PLANNING COMMISSION STAFF REPORT

TO: Kittitas County Planning Commission
FROM: Mackenzie Moynihan, Staff Planner
DATE: May 19, 2008 for May 27, 2008 Public Hearing
SUBJECT: Graham Rezone (Z-08-02) and Graham Family Short Plat (SP-08-02)

Proposal: Graham Rezone (Z-08-02) and Graham Family Short Plat (SP-08-02)

GRAHAM FAMILY SHORT PLAT SP-08-02 PORTION OF SW 1/4 OF SECTION 4, TOWNSHIP 19 NORTH, RANGE 16 EAST, W.M.

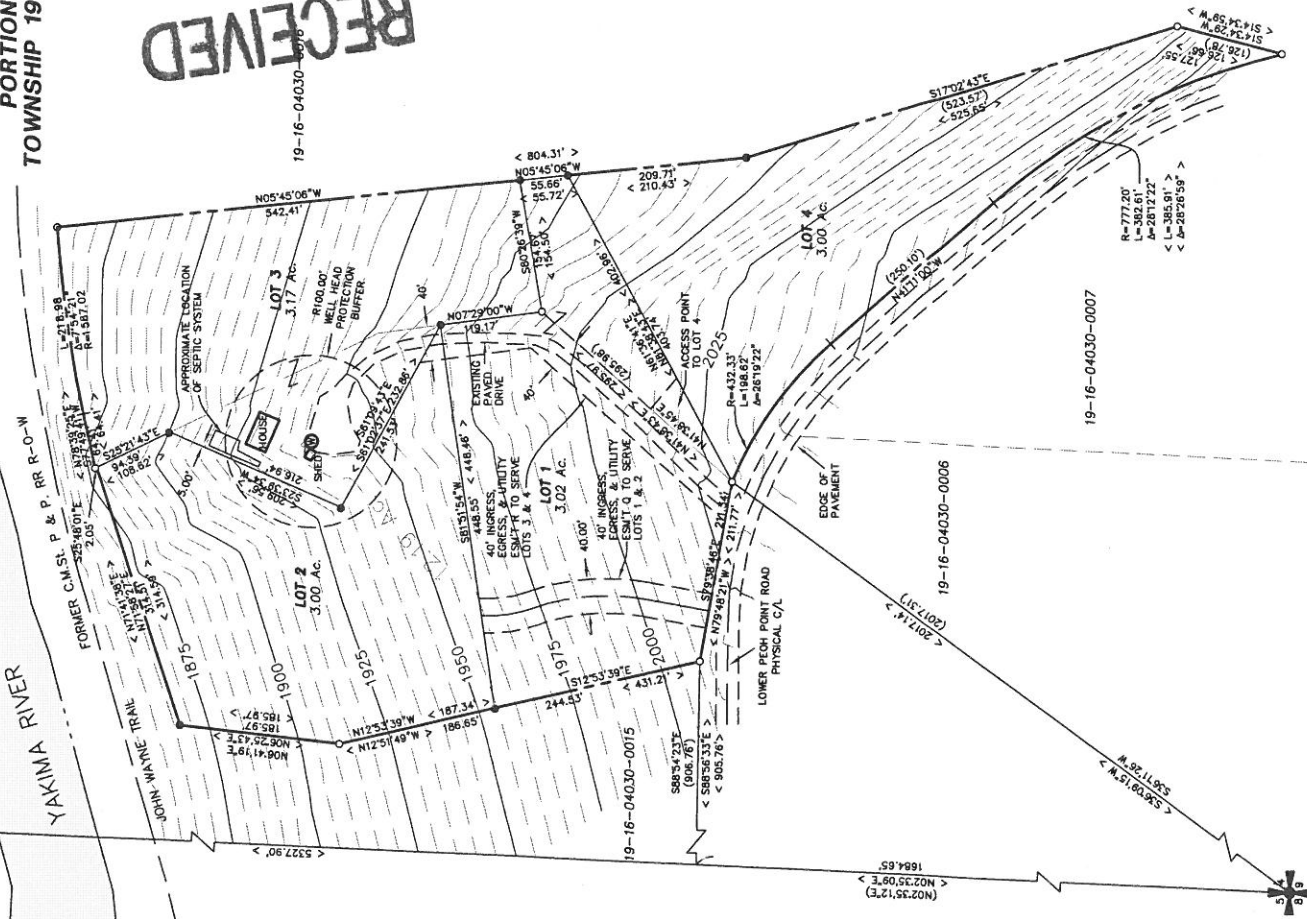
- a. The applicant shall be responsible for meeting or exceeding all conditions and requirements set forth by the Department of Public Works, as listed in the attached memorandum.
- b. A minimum 20’ wide access and utility easement shall be shown on the final mylars for the proposed access location to Lot 4 of the Graham Family Short Plat.

- d. The Graham Family Short Plat (SP-08-02) shall be considered as one project and therefore shall be limited to one groundwater withdrawal exemption for all four (4) proposed lots.

- f. All wells serving the Graham Family Short Plat (SP-08-02) shall be metered and records documenting water usage shall be kept and made available for public inspection. The cumulative daily withdrawal limit of all wells combined shall not exceed the 5,000 gallon per day exemption set forth by the Department of Ecology.

- a. Addresses of all new residences shall be clearly visible from both directions at the county road.
- b. The applicant shall consult with the local school district to determine a safe location for a school bus stop and said location shall be depicted on the final mylars.
